A1 Birtley to Coal House

Scheme Number: TR010031

Change Request

A1 Birtley to Coal House (TR010031) – Material Change request

**ALLERDENE BRIDGE (3 SPAN OPTION)
PLAN**
SCALE 1:1000

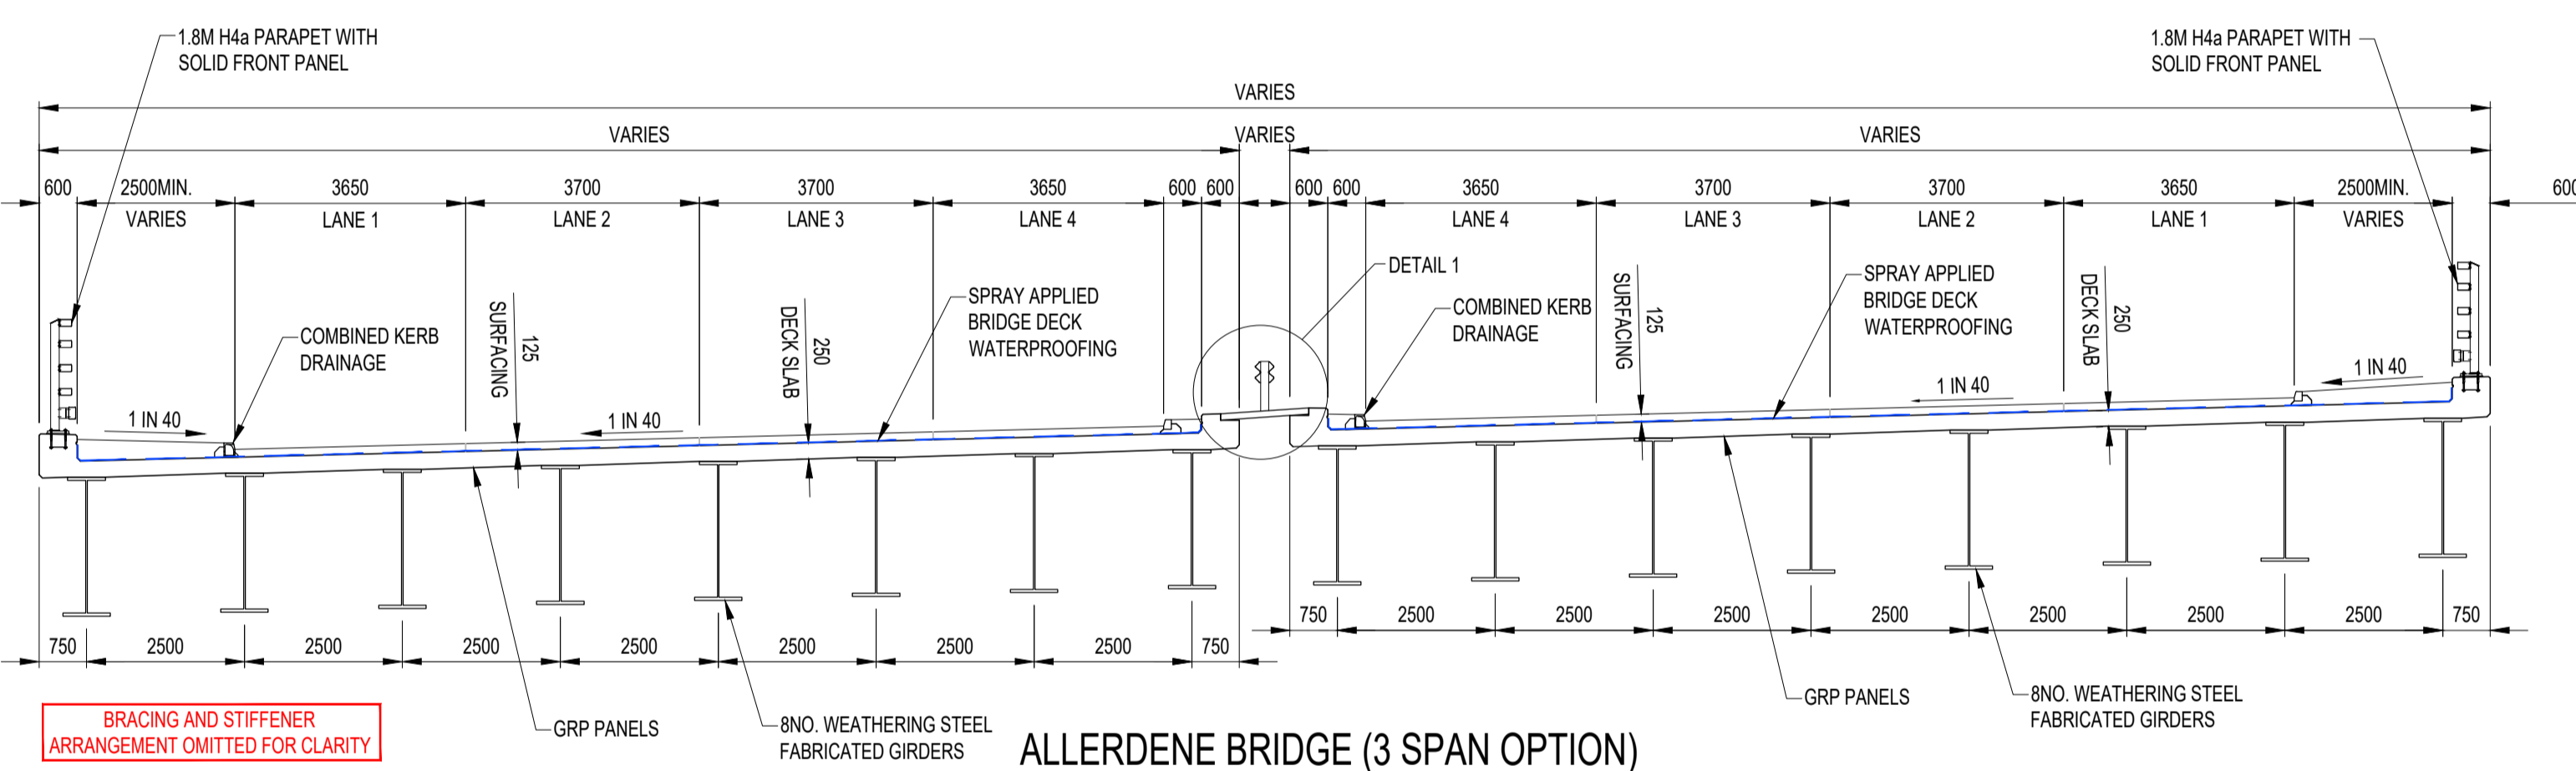
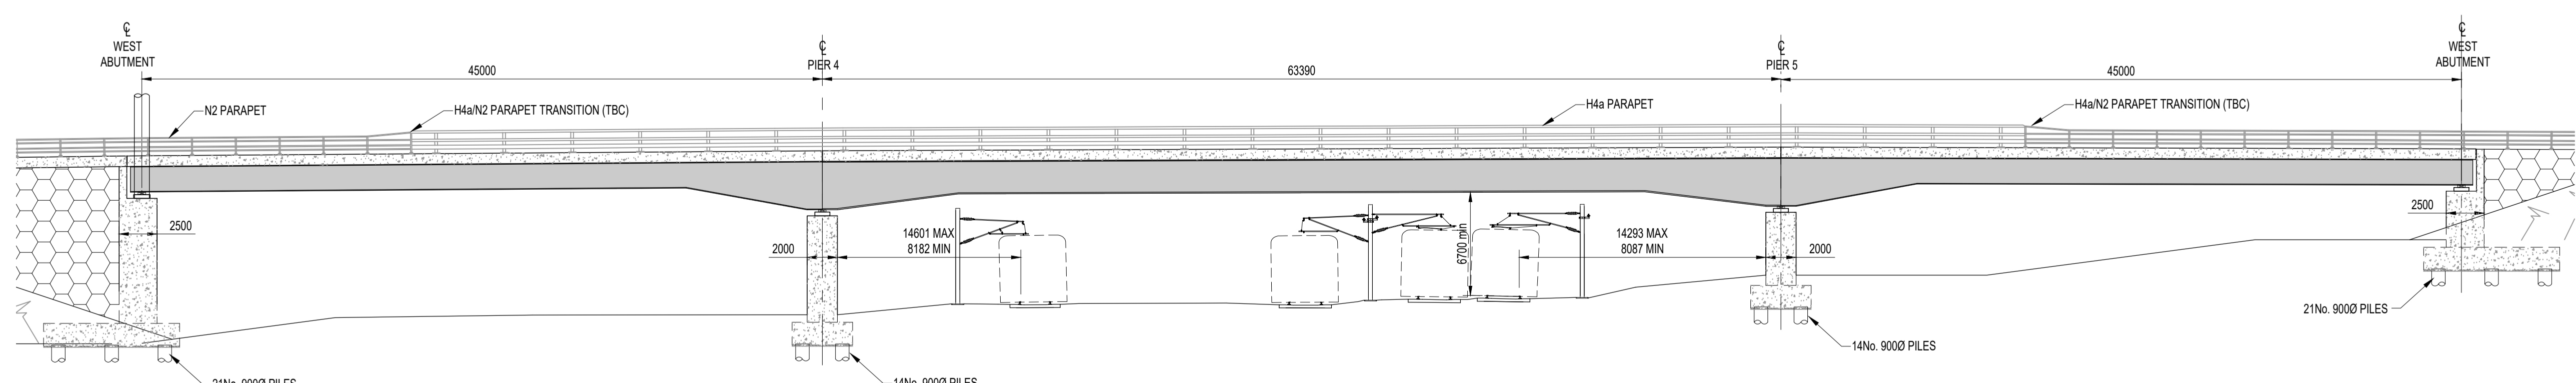
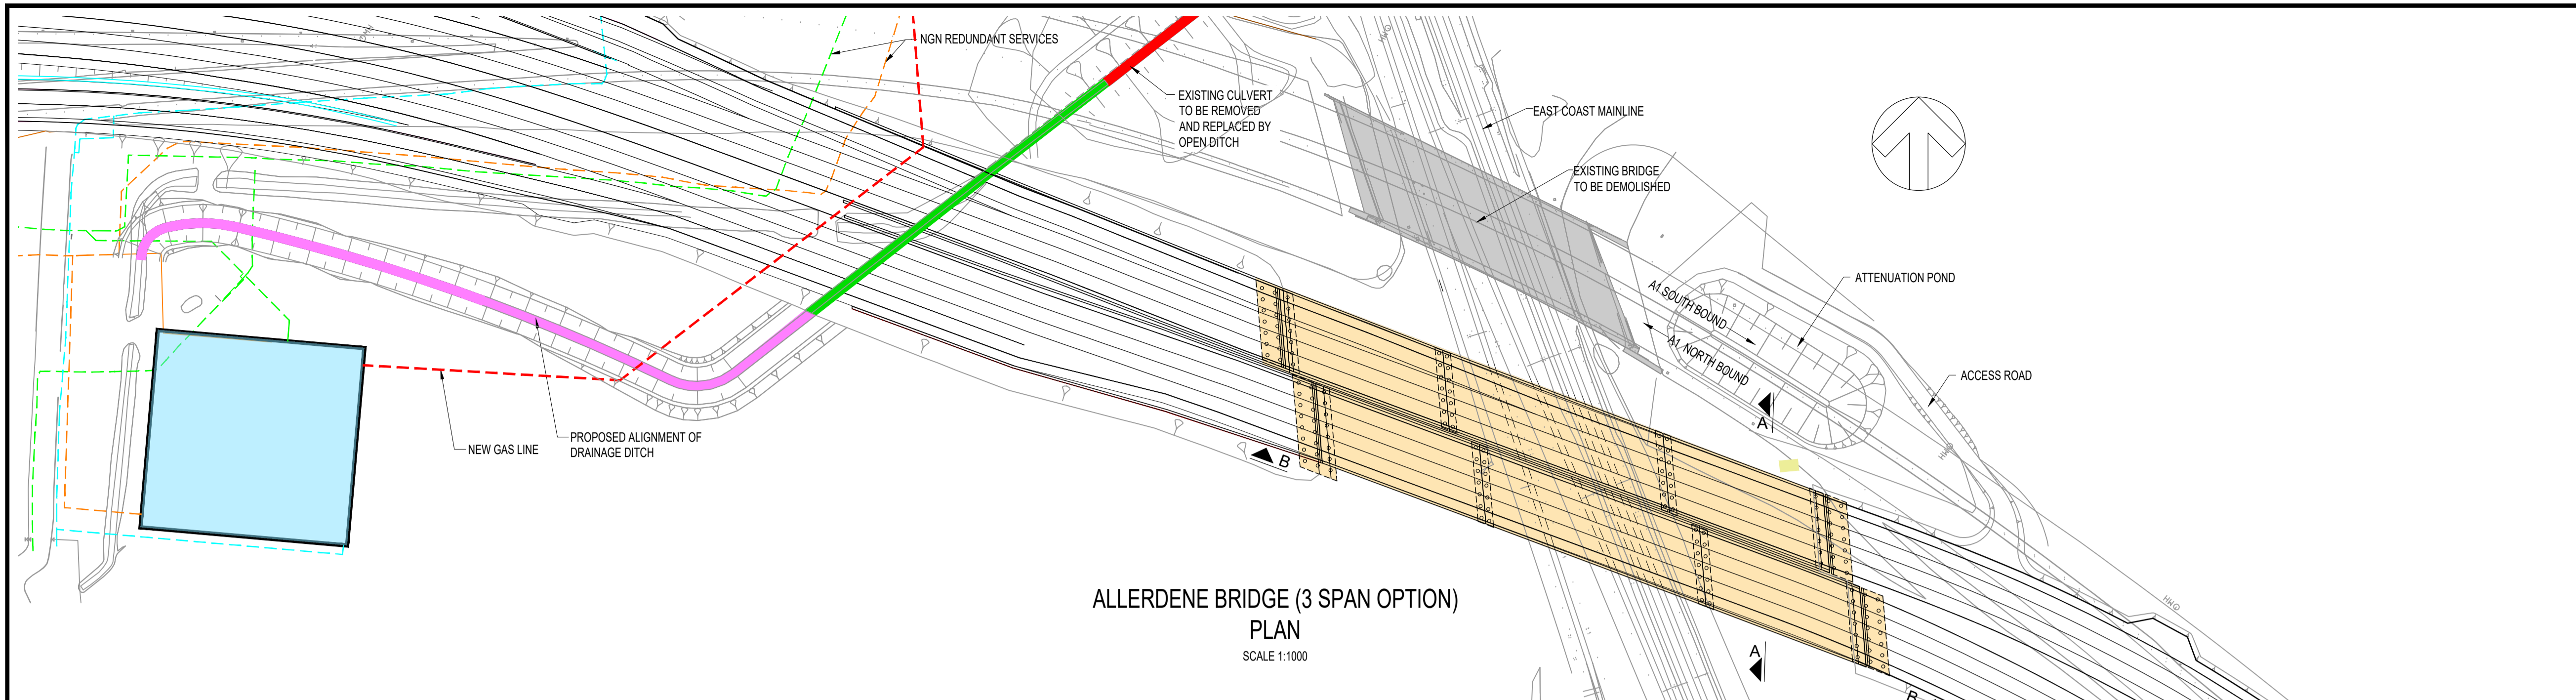
- **Change 1** - The inclusion of further design flexibility in relation to the proposed replacement Allerdene Railway Bridge. The draft DCO **[REP2-044 and REP2-045]** currently allows for the replacement of Allerdene Railway Bridge by a single span integral bridge (Allerdene Embankment option) or a 6/7-span viaduct (Allerdene viaduct option). It is further proposed to enable the inclusion of a design for a three-span viaduct (Allerdene three-span viaduct option) within the DCO Application.

The Applicant proposes to amend the Application to include a three-span viaduct option with reinforced earth embankments to be constructed as a replacement for Allerdene Railway Bridge over the East Coast Main Line. This relates to Works No 5a of the Draft DCO **[REP2-044 and REP2-045]**, which currently provides two design options for the replacement of Allerdene Railway Bridge: a single span integral bridge (Allerdene Embankment option) and 6/7 span viaduct (Allerdene viaduct option). The proposed change would be a new third design option to introduce further flexibility to the delivery of the structure. A drawing of the Allerdene three-span viaduct option is provided in the Structures Engineering Drawings and Sections (see Sheet No.16, **[REP2-042]** Revision 2a submitted for Deadline 4).

The main benefits of this proposed change are that it would reduce the amount of material required to construct the approach embankments, reduce the construction programme by an estimated 6 month period (when combined with Change 3 for additional land) and reduce the duration of traffic delays to road users due to the shorter construction period. This option would also reduce the steelwork tonnage required to support the bridge deck, require fewer rigid inclusions and other design benefits compared to the other two options.

Figure 2-1 Proposed Lane Narrowing

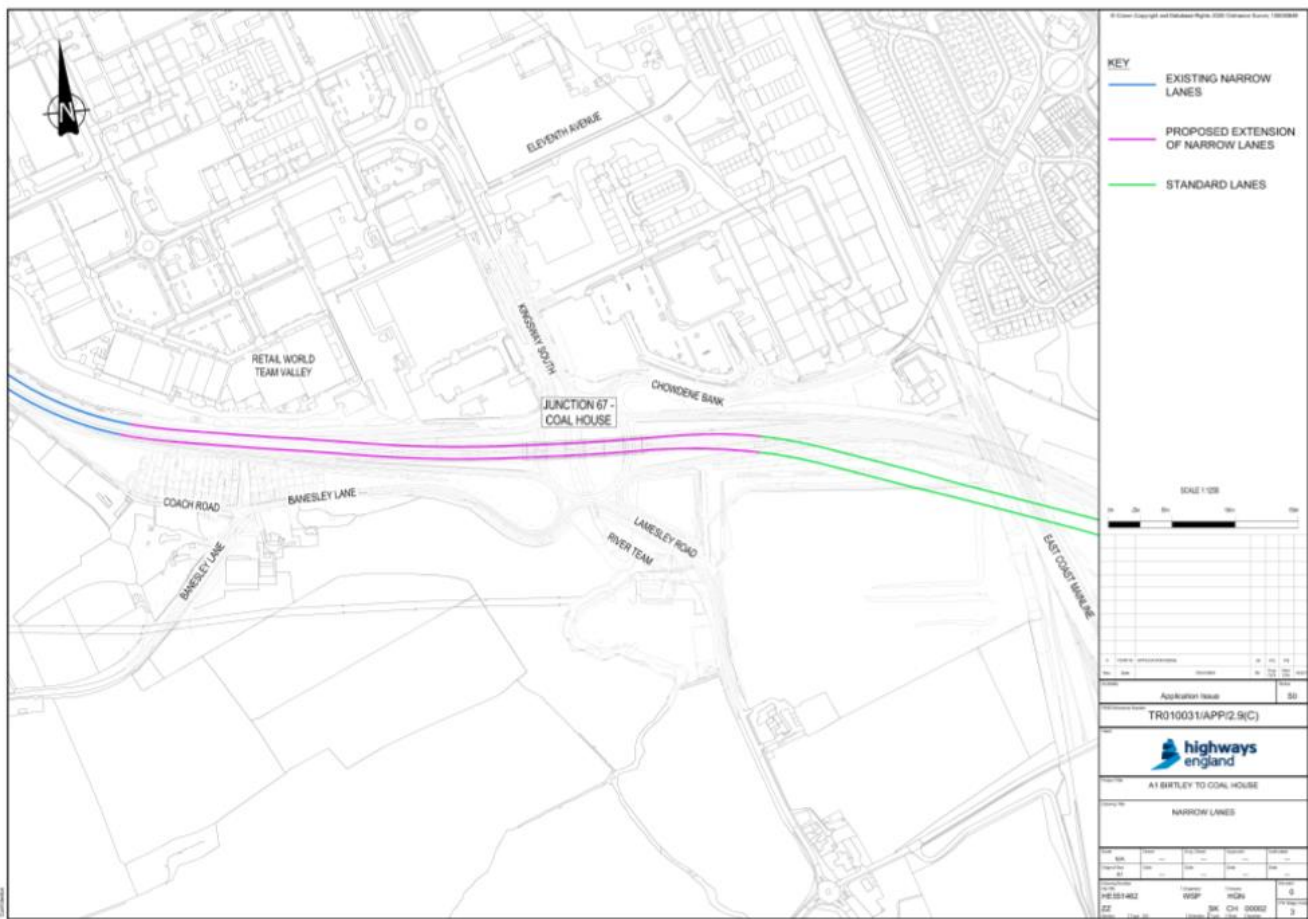
The Applicant proposes to amend the Application to include narrower lanes from land north of junction 67 (Coal House) and up to Kingsway Viaduct (at approximate chainage 11150) for a length of approximately 750m. This is a change from the current Application which seeks powers to provide full width lanes through the entire length of the Scheme. Applying this narrower cross section would reduce the structural widening at Kingsway Viaduct by approximately 5m (2.1m compared to 7m in the Application currently). It may also be necessary to amend the existing Traffic Regulation Order No. 1013 The A1 Trunk Road (Gateshead/Newcastle Western Bypass) (Width Restrictions) Order 2016 (TRO), which prohibits heavy goods vehicles from the offside lane and extend this to the south into the Scheme extents.

**Figure 2 - Indicative layout for the Additional Land**

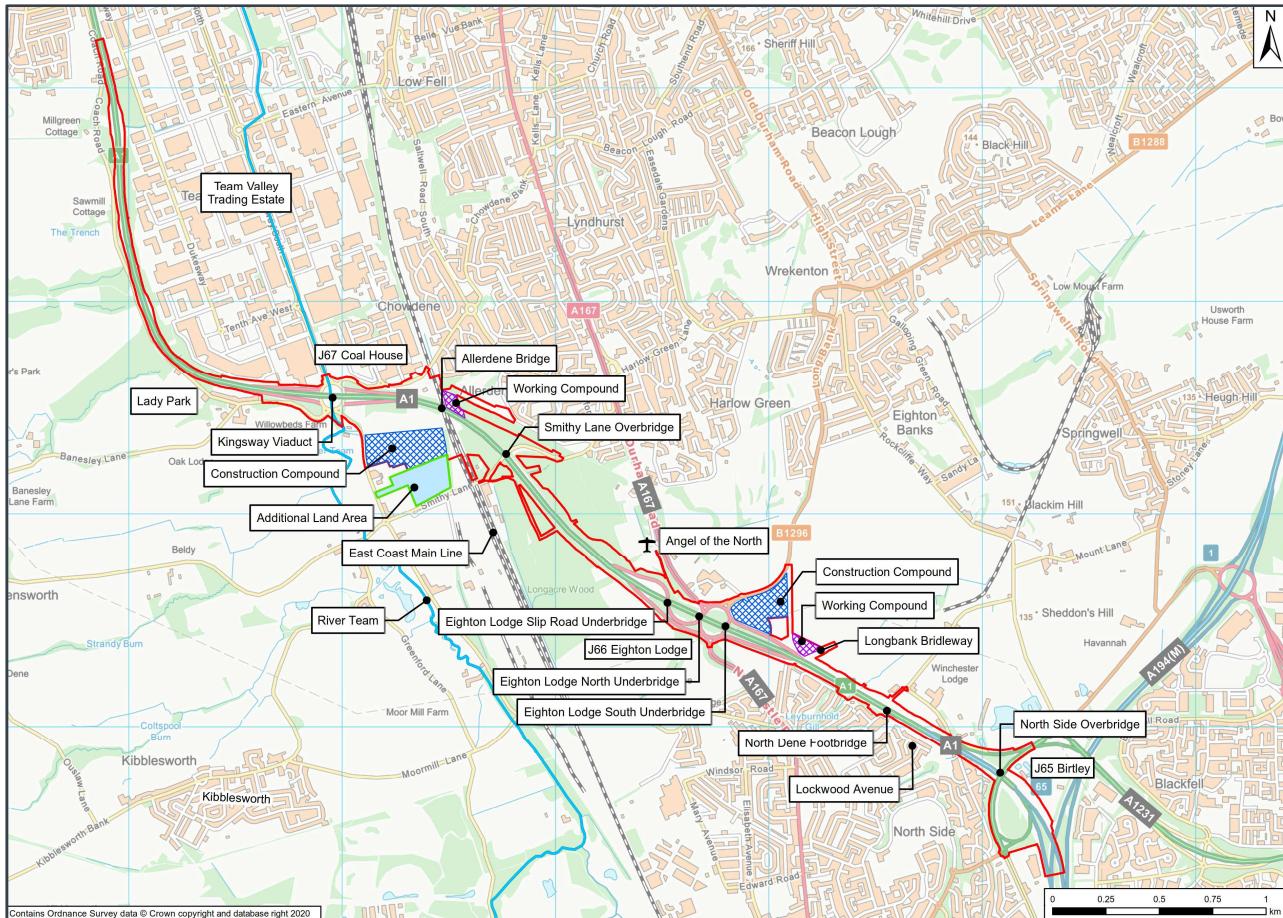
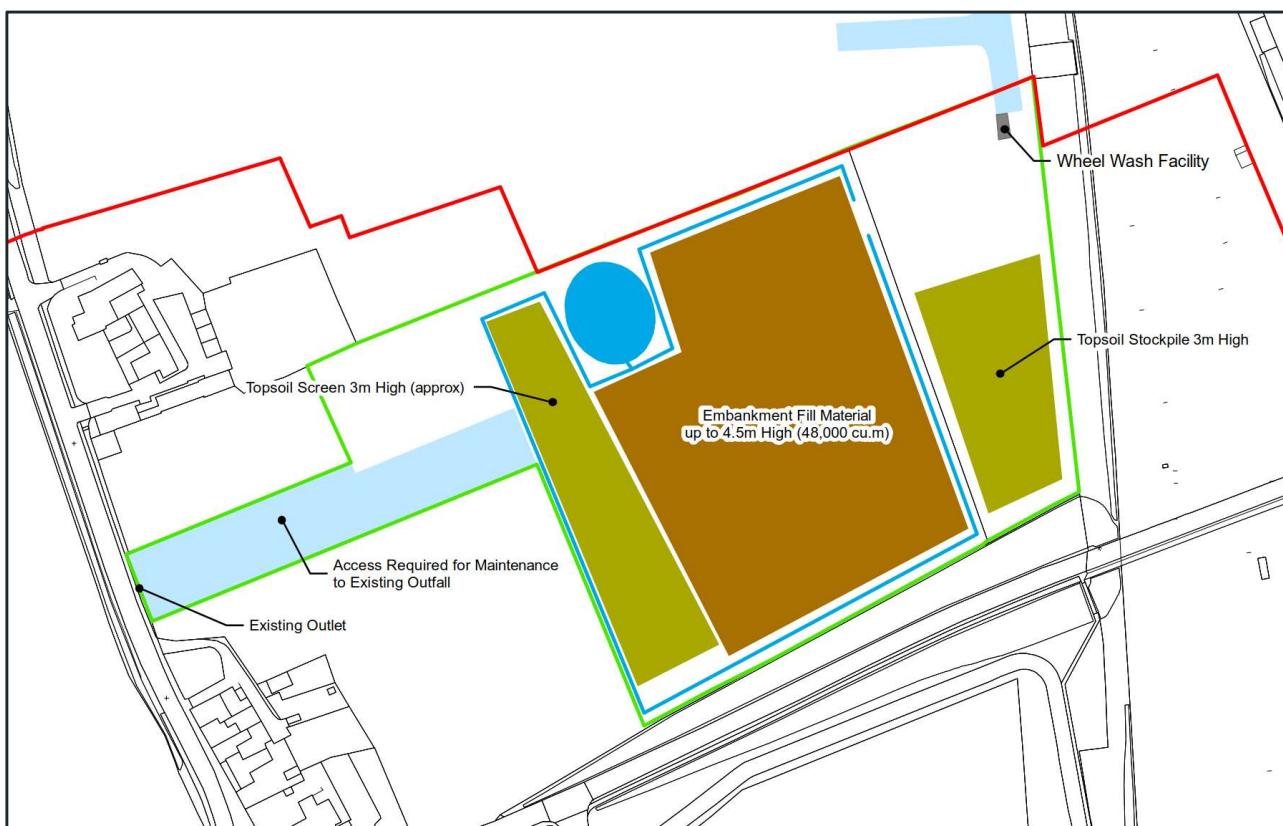
- **Change 3-** The inclusion of additional land within the application at junction 67 (Coal House) for an extension of the existing site compound, to be used for material stockpiling. This land currently sits outside the proposed Order limits and it is proposed that powers of temporary occupation are extended to the land during construction of the Scheme.

The Applicant proposes to amend the Application to include additional land to provide an optimised temporary materials stockpile during construction of the Scheme. The additional land is approximately 5ha in size and is shown as plot 3/13a on the Land Plans [REP2-037], Revision 3 submitted for Deadline 4. A temporary construction access road would also be required to access the additional land from the adjacent construction compound site at junction 67 (Coal House), as well as a wheel wash facility and temporary water management control for the import of fill material by road.
